Martin Place Station Precinct North Site Stage 2 (SSD-9270-PA-4)
Northern façade kitchen exhaust discharge

The Department has reviewed the submitted documentation, including the *Condition B5, B6 and B7 discharge request #4 – Design excellence and design integrity review*, prepared by Ethos Urban dated 21 December 2020.

Figure 1 Approved (top) and proposed (bottom) northern elevation

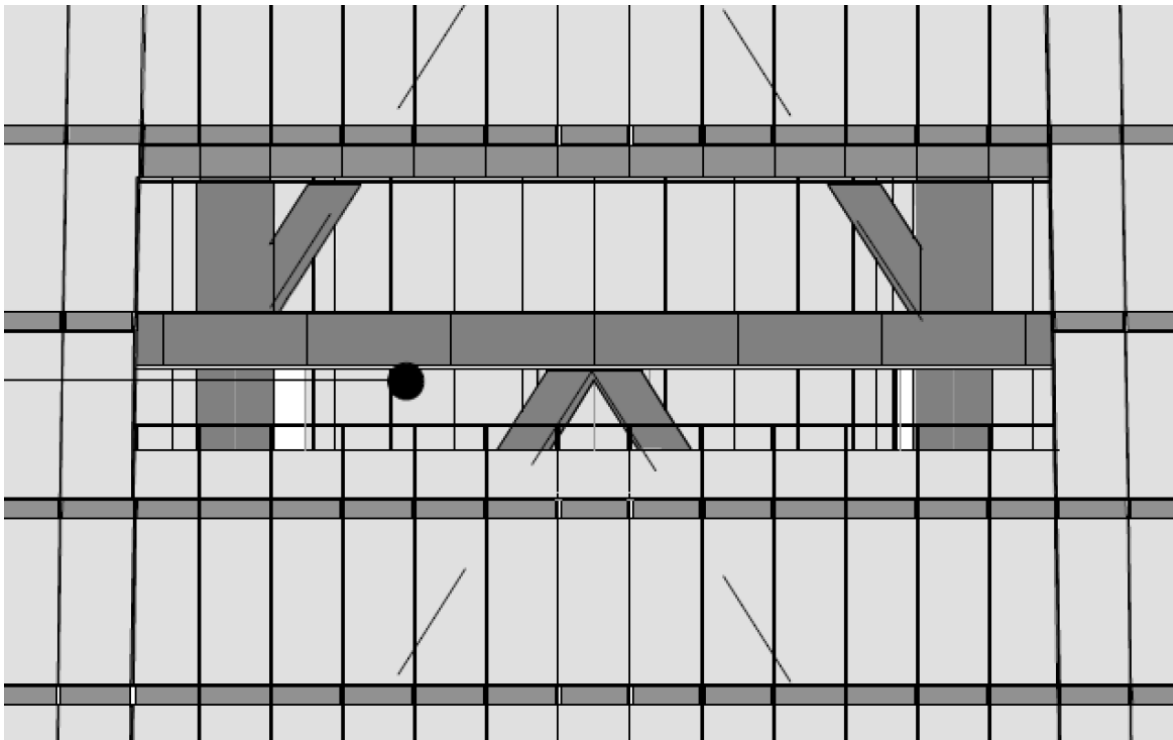
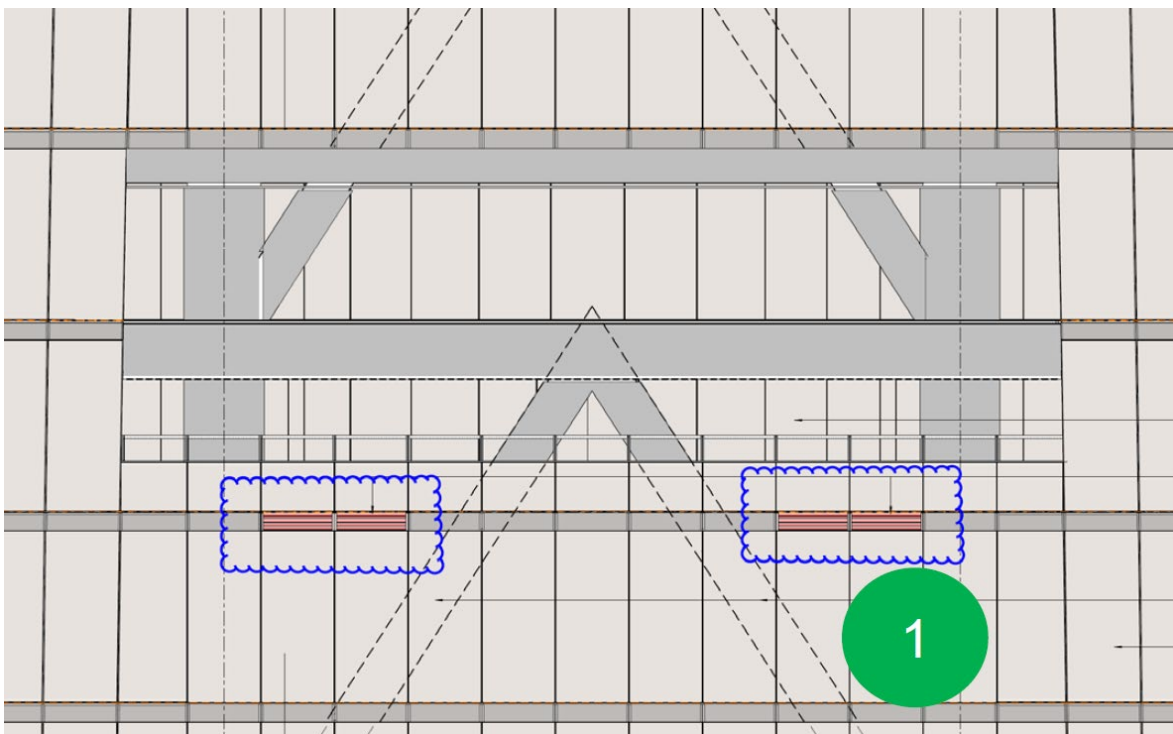
The Department has considered the addition of kitchen exhaust louvres (within level 10 of the northern façade of the North tower) and is satisfied the proposed changes are minor, will not impact on the design excellence qualities of the approved building and are not inconsistent with the approved design.

Accordingly, as the Planning Secretary's nominee, I am satisfied the requirements of Conditions B5, B6 and B7 of SSD-9270 have been met and the proposed changes can proceed without a review by the DRP or a Section 4.55 modification application.
